KIRKLEES METROPOLITAN COUNCIL INVESTMENT & REGENERATION SERVICE

DELEGATED DECISION TO DETERMINE PLANNING APPLICATIONS

Reference No:	2026/62/91139/E
Site Address:	1, Charnwood Bank, White Lee, Batley, WF17 8PY
Description:	Erection of side and rear extensions, formation of driveway with dropped kerb to front elevation and associated works
Recommending Officer:	Elenya Jackson

DECISION – REFUSED

PROPOSED SITE/BLOCK PLAN 1:500

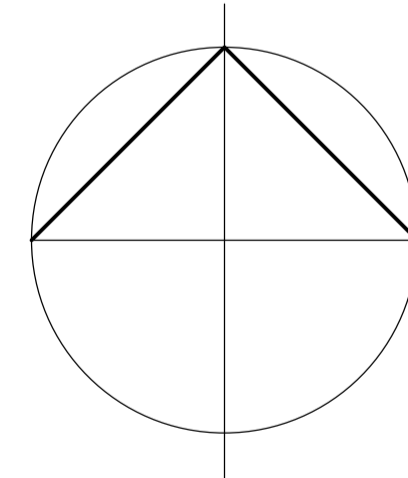
The proposal would see the creation of a parking space to front, this is an element of the scheme not previously proposed and would facilitate the creation of a dropped curb and parking space which would be at an oblique angle within the site due to the close proximity of the property to the street. The parking of a vehicle could only be possible by utilising all the area to the front of the site, which would become parking dominated hard standing.

The appearance of this element of the development is considered to be visually incongruous in the context of the street which is characterised by site frontages consisting of soft landscaping. The angled nature of the parking area, and fact there would need to be a degree of alterations to the site to accommodate such a space coupled with the prominence of this part of the site leads to the conclusion this element of the proposed development would be visually harmful and contrary to policy LP24 of the Kirklees Local Plan as well as the House Extensions and Alterations SPD.

KC Highways have raised concerns as the parking location/access to be created as part of the application as parking provision should be parallel to the highway to ensure manoeuvrability would not obstruct or inconvenience other users of the network. The proposed parking space is considered to be at a contrived angle that could require the utilisation of neighbouring land to access.

A fence has been erected around the site which does not benefit from planning permission; however, this would impede visibility splays of the site.

It is considered that the manoeuvres required to utilise the proposed parking space would be such that it would not be easily usable as a space and would conflict with pedestrian users as well as vehicles accessing Charnwood Bank given the siting of the access point in close proximity to the Junction. It is noted the dwelling was designed with vehicular parking provided to the rear of the plot, and it is considered the highway safety implications of an access point to the front were such that the vehicular parking arrangements for the site as implemented were dictated as a result.

Proposed Rear and Side Elevations

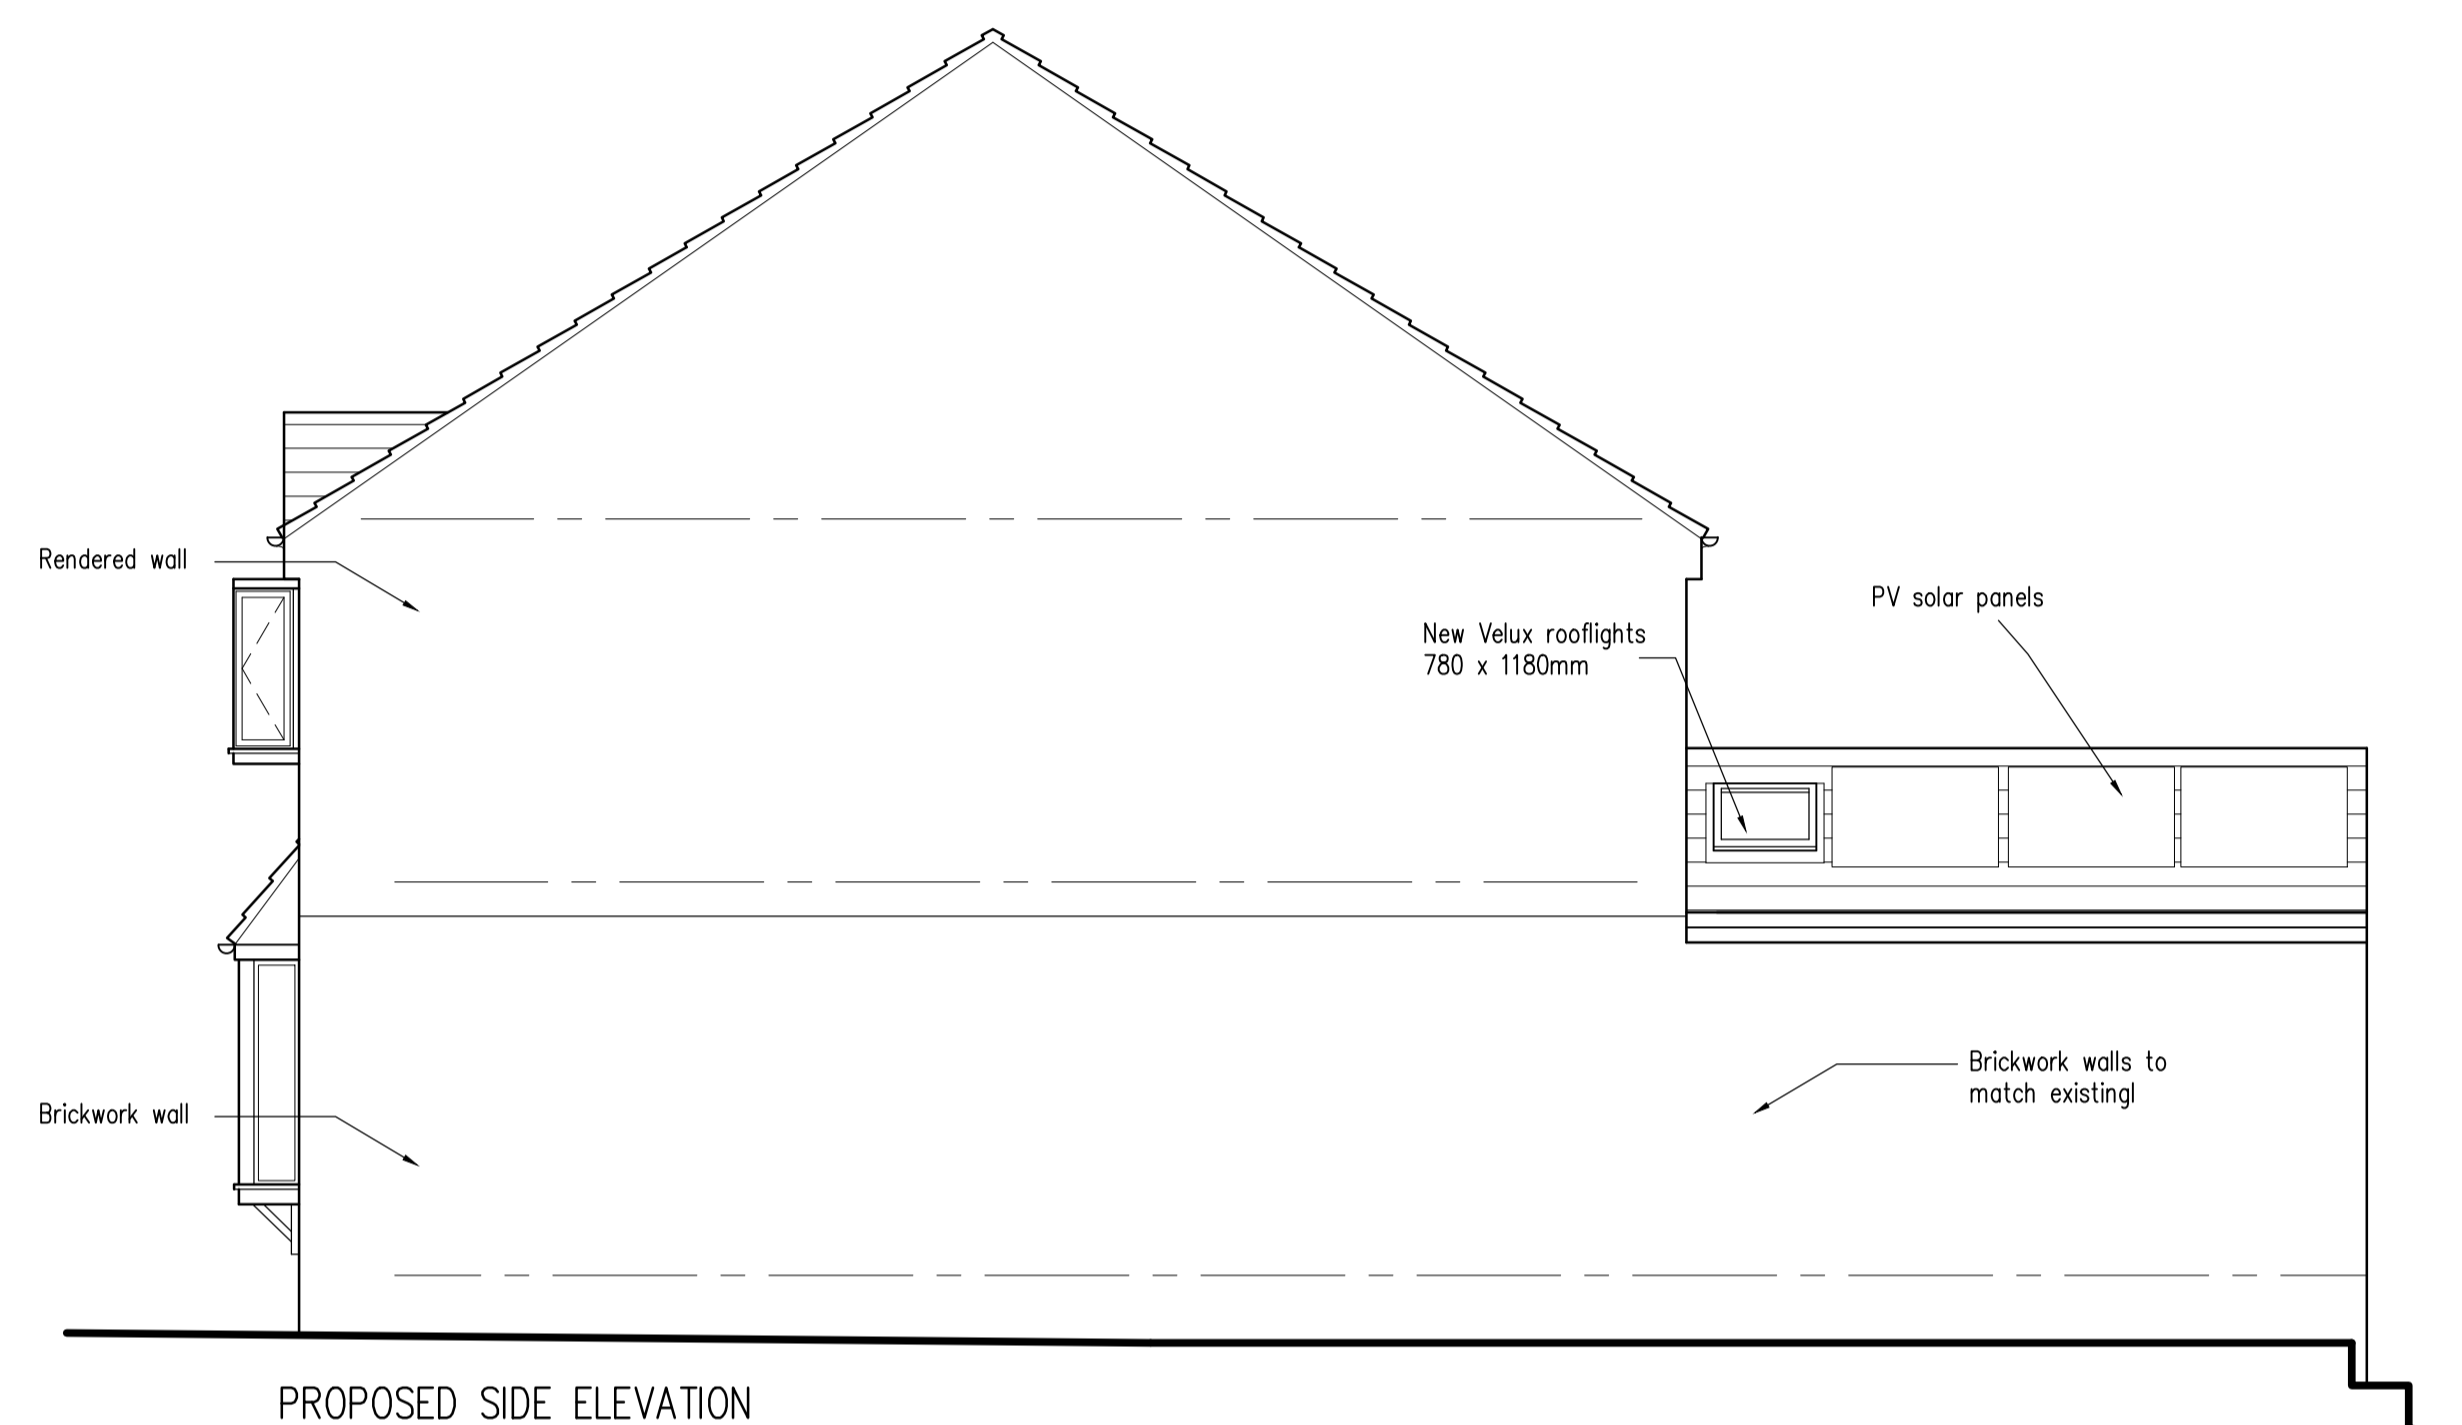
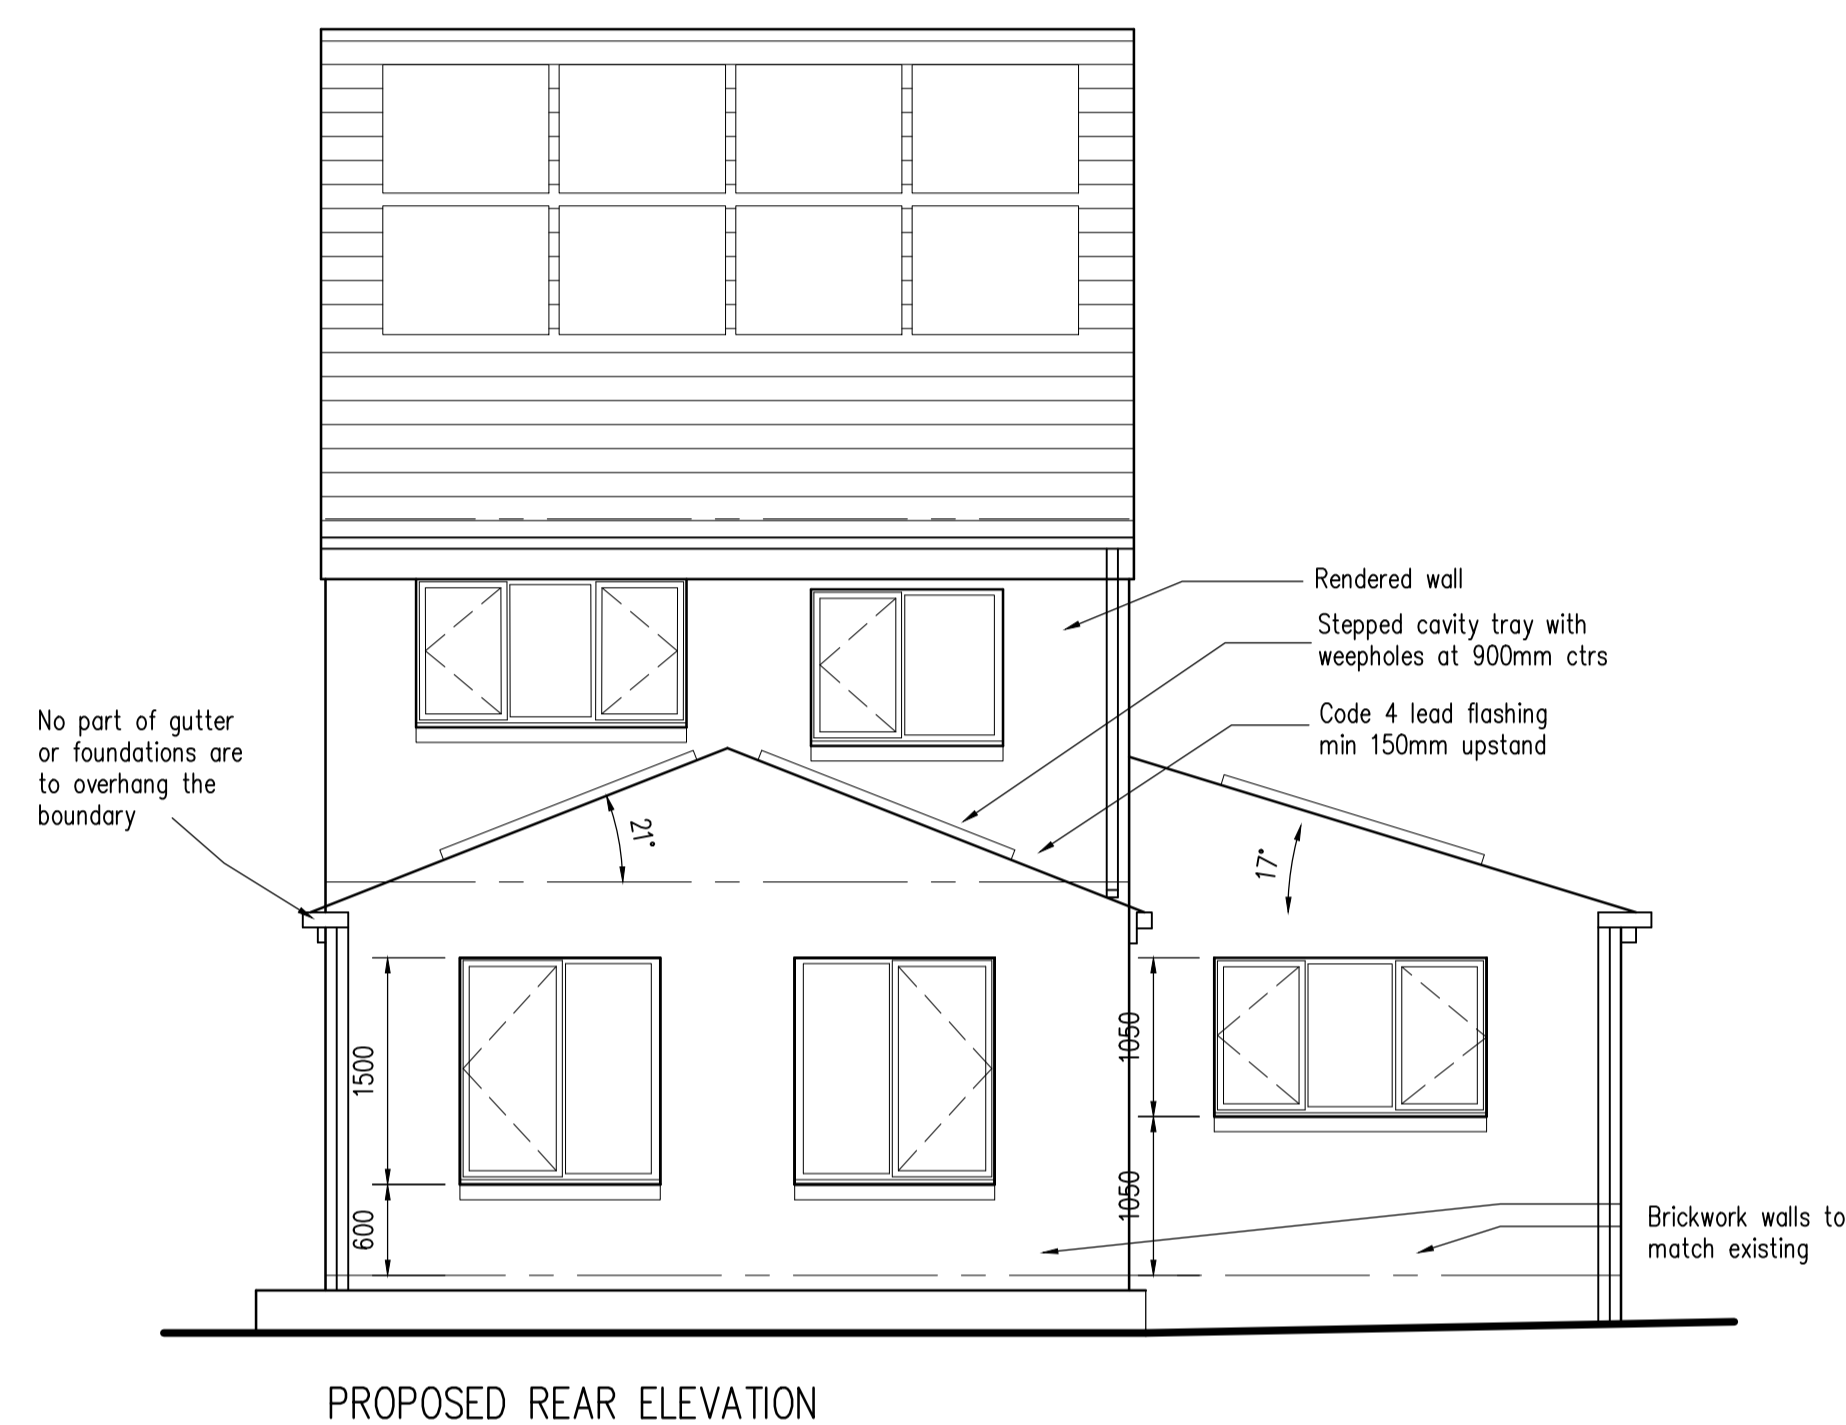
The side extension would project 3.2m beyond the side elevation of the existing dwelling and have a length of 8.7m with a lean-to roof with a maximum height of 3.7m.

The rear extension would project 4.5m beyond the rear of the house and have a width of 5.3m with a maximum height of 3.3m.

Overshadowing/loss of light/overbearing: The proposed extension would project approximately 4.5m beyond the rear of no.3. Officers consider that there would be an alteration to the existing relationship between the dwellings; however, the extension would be set approximately 2.3m away from the side of no.3 and any overshadowing would be limited in duration during the day. On this basis, the impact upon the occupants of this neighbouring property is not considered to be significantly detrimental to warrant a reason for refusal.
